# Appeal Decision

**Appeal Ref: APP/R4408/D/24/3336265**

**11 Beech House Road, Hemingfield, Barnsley S73 0PF**

- The appeal is made under section 78 of the Town and Country Planning Act 1990 (as amended) against a refusal to grant planning permission.
  - The appeal is made by Mr Ian Wilkinson against the decision of Barnsley Metropolitan Borough Council.
  - The application Ref is 2023/0831.
  - The development proposed is bedroom loft dormer over existing garage ridge height increase plus front car port.
-

A3 PAPER- PROPOSED ELEVATIONS 1  
1:100

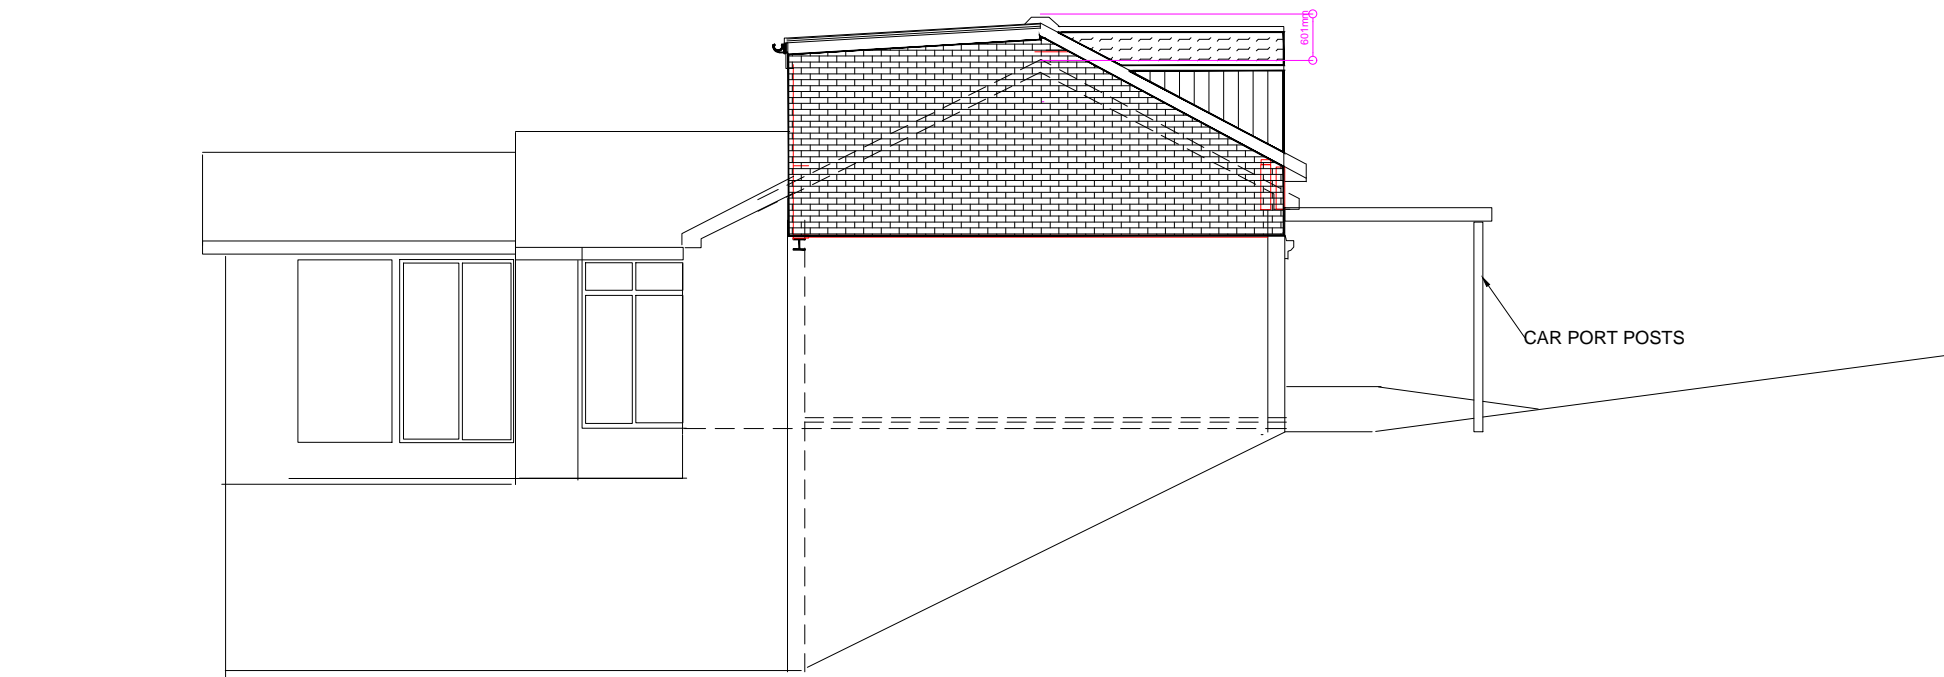
7. The proposal is to raise the roof above the existing garage to provide accommodation above it, including two gabled dormer windows to the front and a box dormer to the rear. The garage door would also be reduced, and a window added alongside a door. A separate car port would be added to the front elevation.

9. The proposed dormers above the front of the garage would be flush to its eaves and run back to the ridge. Although there are dormers of similar style at 9 Beech Road, together with the dormer at the rear, the scale of the proposed dormers would unbalance the simple, well-proportioned appearance of the host property.

PROPOSED FRONT ELEVATION

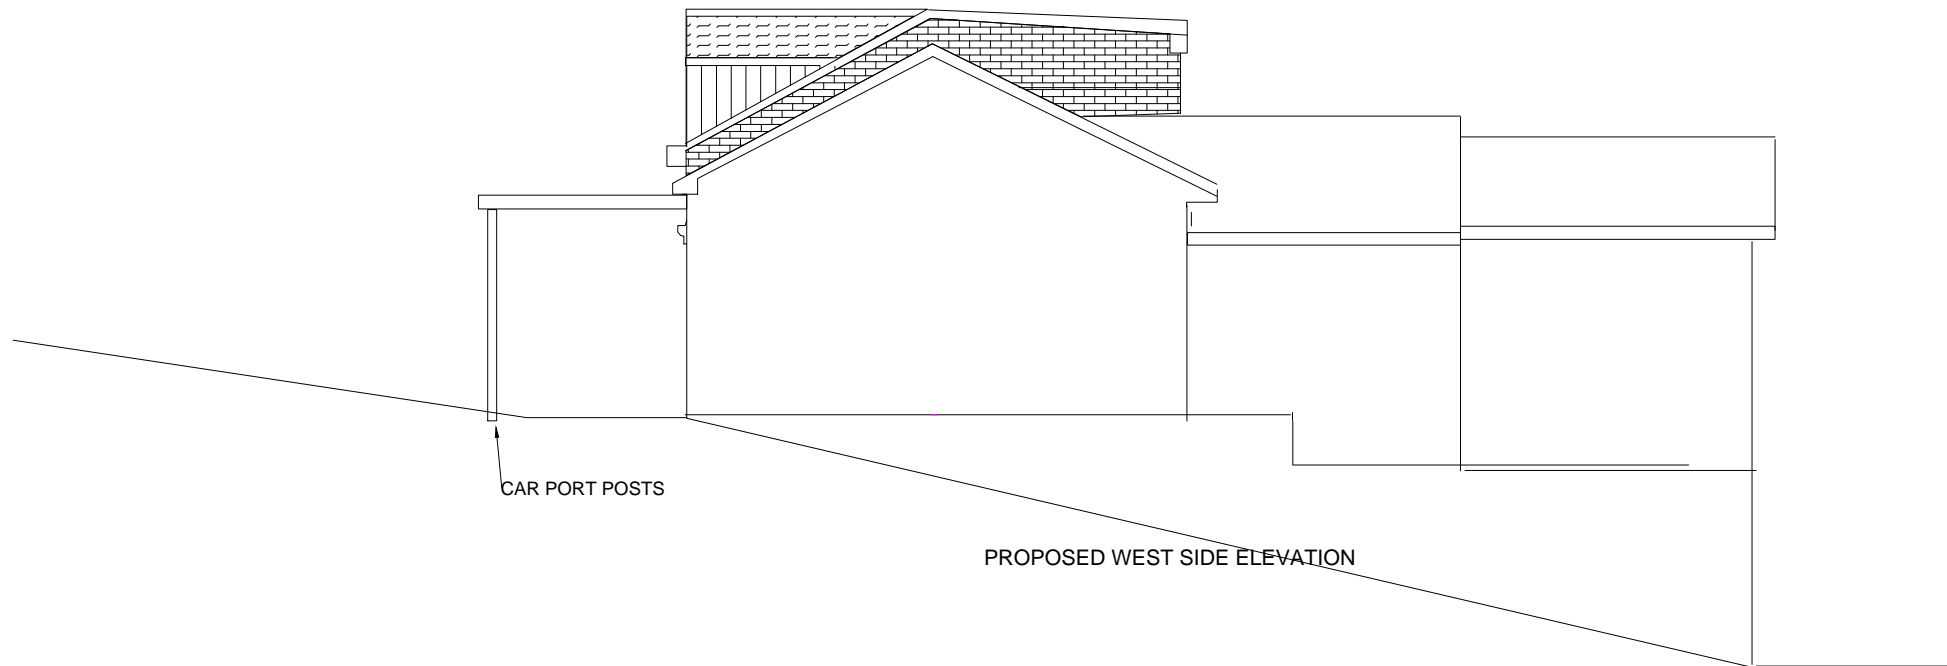
8. The proposed change to the height of the garage would reverse the current stepped effect of the roof line, thereby changing its prominence in relation to the main part of the property. Although the increase in the height of the garage roofline would appear similar to those of neighbouring properties it would appear dominant and overbearing in relation to the host property.

10. In light of their appearance and prominence, the proposed alterations to the garage would also represent visually obtrusive additions to the street scene.

11. The proposed car port would have a polycarbonate roof and be located over one of the windows and the front door of the main part of the property. The size, materials and design of the proposed car port would be out of keeping with the style and appearance of the host property and would appear incongruous within the wider street scene.
